WEST SUSSEX COUNTY COUNCIL CONSULTATION

TO:	Arun District Council- FAO: Simon Davis
FROM:	WSCC - Highways Authority
DATE:	2 December 2020
LOCATION:	Land North of Yapton Church of England Primary School North End Road Yapton
SUBJECT:	Y/71/20/RES Approval of reserved matters following outline consent Y/88/18/OUT for the erection of 38 No. dwellings, Public Open Space, a play area & drainage features. This application affects Public Rights of Way. More information received.
RECOMMENDATION:	No Objection

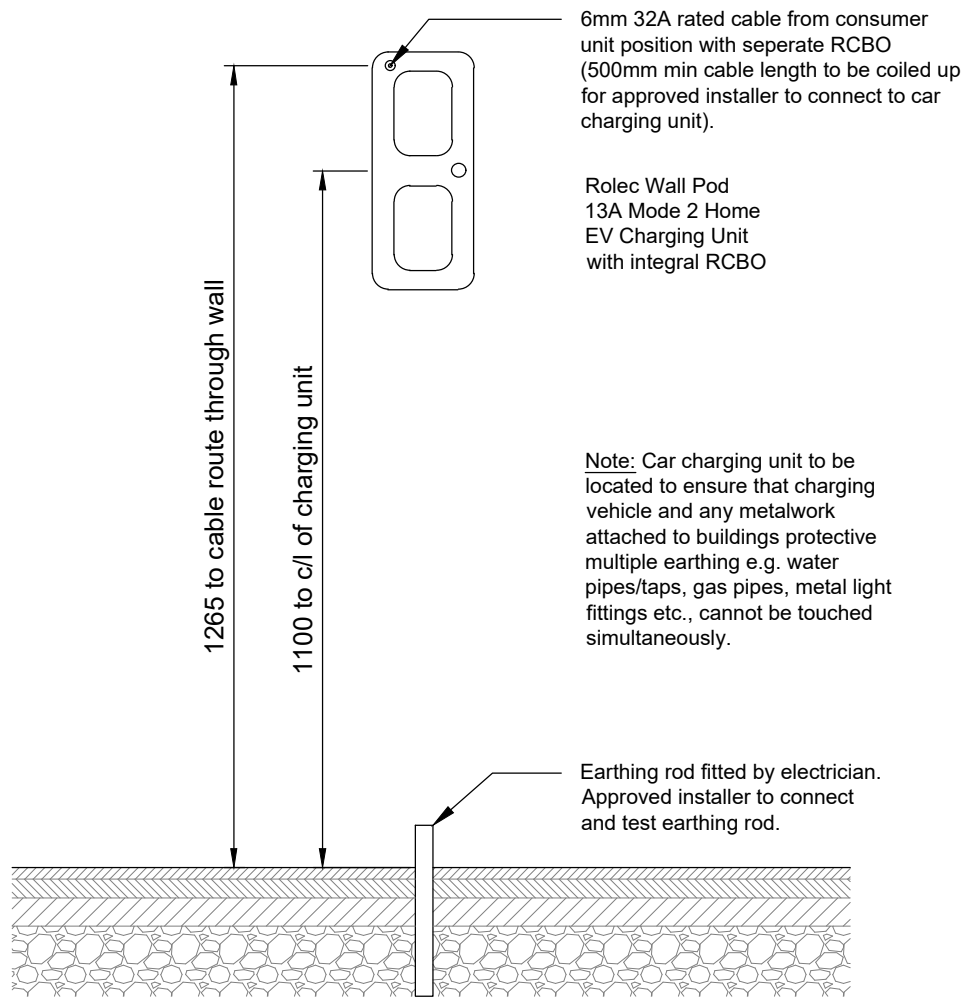
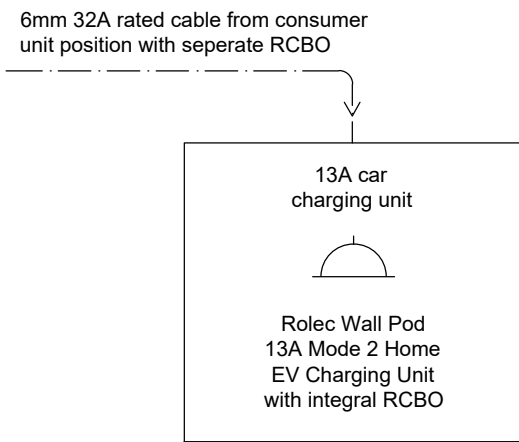
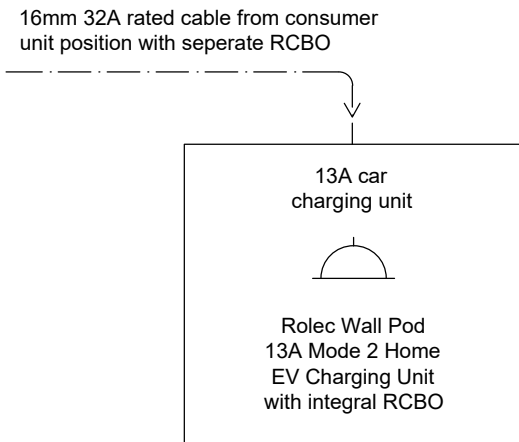
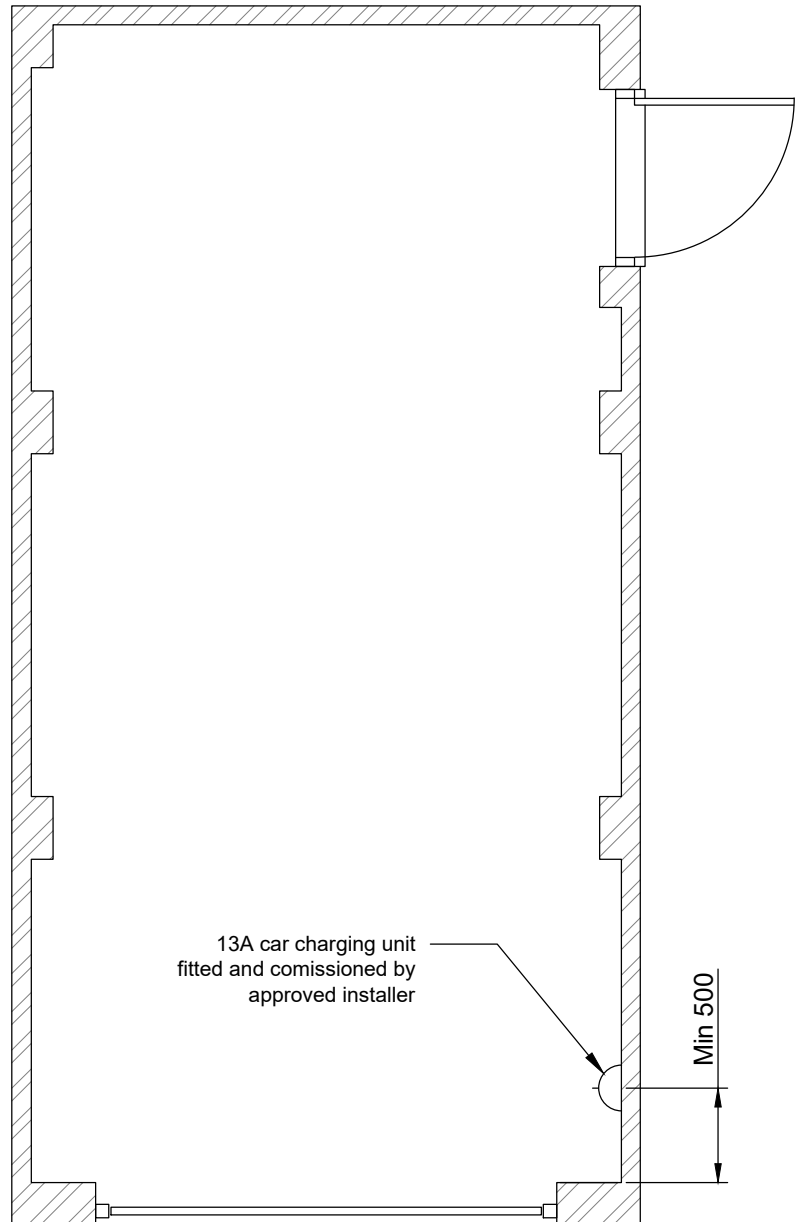
In summary the LHA are satisfied that outstanding reserved matters have been suitably addressed. The LPA may wish to secure the demonstrated details of car parking include electric vehicle charging, cycle parking and CEMP as per approved plans/documents. The TP should also be secured as per approved document, to ensure it is maintained in perpetuity.
